From: Richard Stefanski [REDACTED]
Sent: 18 November 2021 11:08
To: Daun Johnson <Daun.Johnson@arun.gov.uk>
Subject: RE: Request for further information BR/261/21/PL

PROPOSED SECOND FLOOR PLAN  
Sc. 1:100

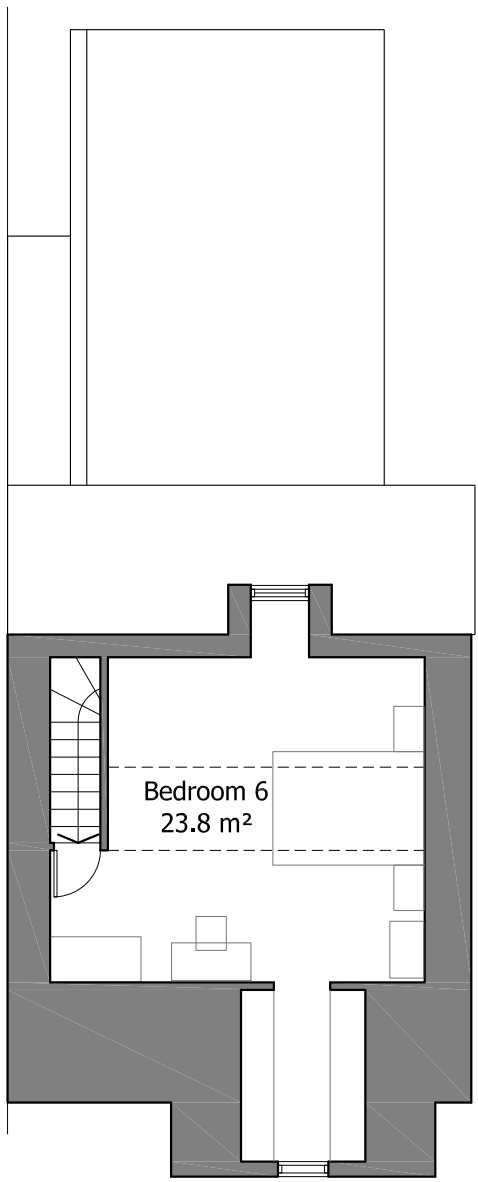
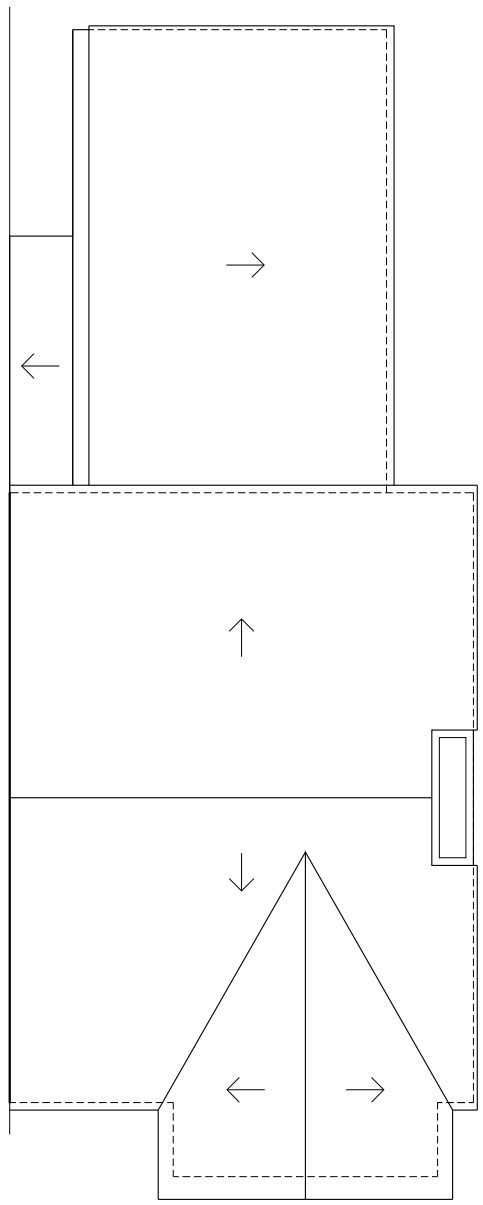
Is the studio on the second floor self contained?

See attached 1535 PL 05 A. I've just checked with our client. It will remain as a bedroom which will share the facilities.

- Further to previous email, there are 6 bedrooms that will share the facilities. Drawing PL 05 A has been revised to show this.
